EL PASO COUNTY
STORMWATER MANAGEMENT PLAN CHECKLIST
 LATIGO-EASTONVILLE 8" PVC RAW WATERMAIN

EL PASO COUNTY STORMWATER MANAGEMENT PLAN CHECKLIST

MERIDIAN SERVICE
METROPOLITAN DISTRICT
LATIGO EASTONVILLE WATER
PIPELINE
PLAN AND PROFILE

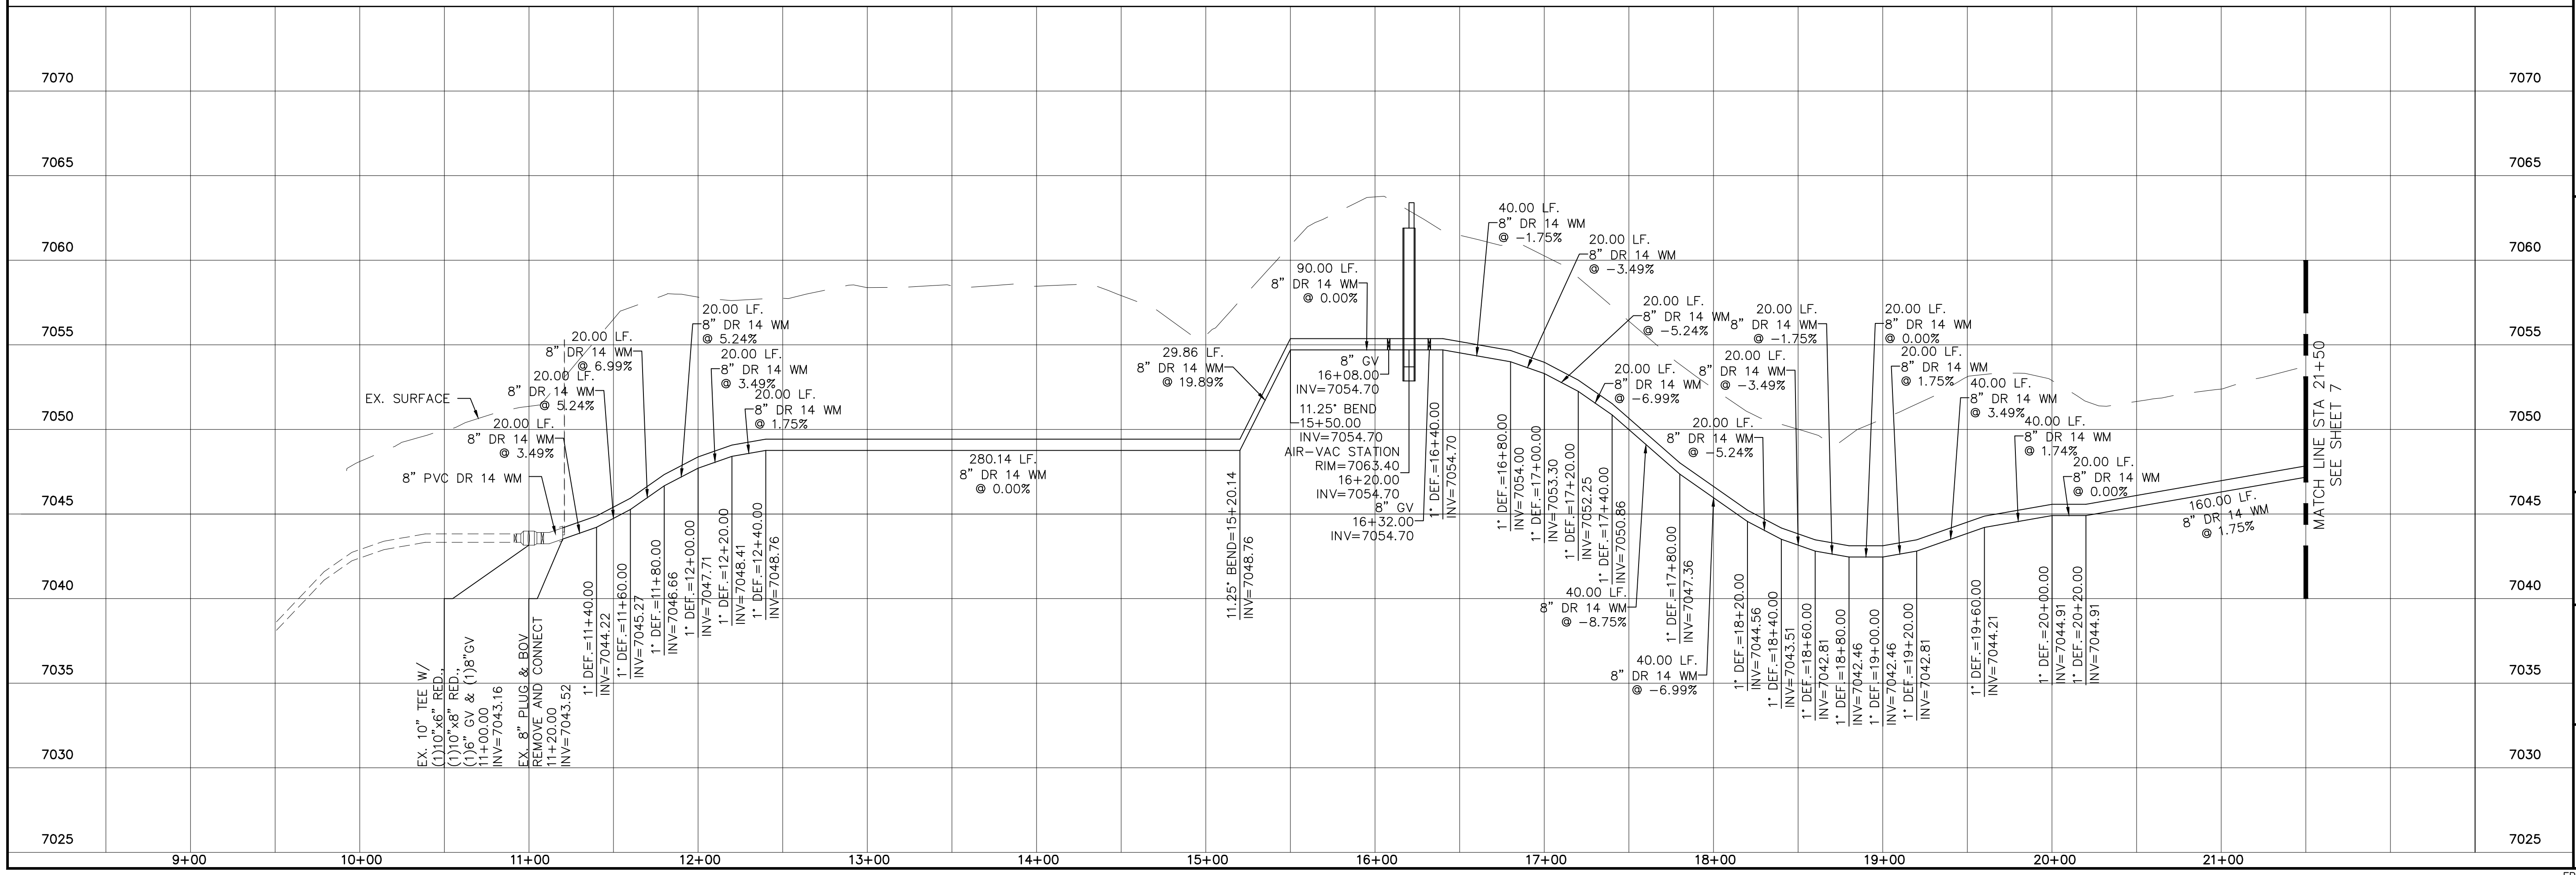
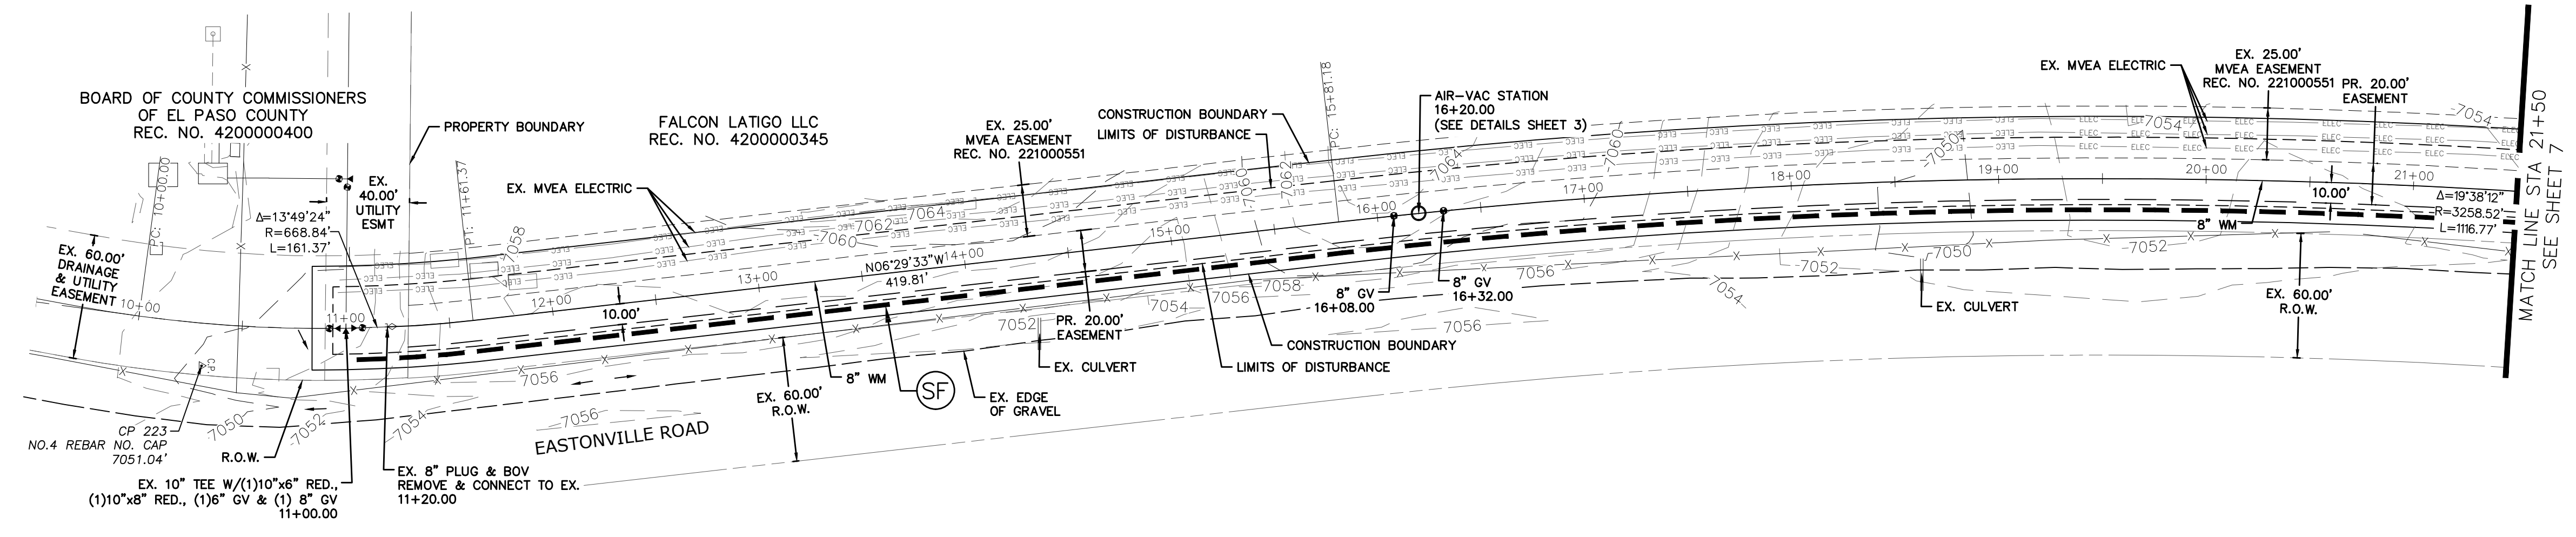
Applicant	EPC
17	SWMP Map to include: GEC Plan reviewed		
17a	construction site boundaries		Y
17b	flow arrows to depict stormwater flow directions Added		N
17c	all areas of disturbance		Y
17d	areas of cut and fill		Y
17e	areas used for storage of building materials, soils (stockpiles) or wastes		Y
17f	location of any dedicated asphalt / concrete batch plants		Y
17g	location of all structural control measures		Y
17h	location of all non-structural control measures		N
17i	springs, streams, wetlands and other surface waters, including areas that require maintenance of pre-existing vegetation within 50 feet of a receiving water		Y
18	Narrative description of all structural control measures to be used. Modifications to EPC standard control measures must meet or exceed County-approved details		Y
19	Description of all non-structural control measures to be used including seeding, mulching, protection of existing vegetation, site watering, sod placement, etc.		Y
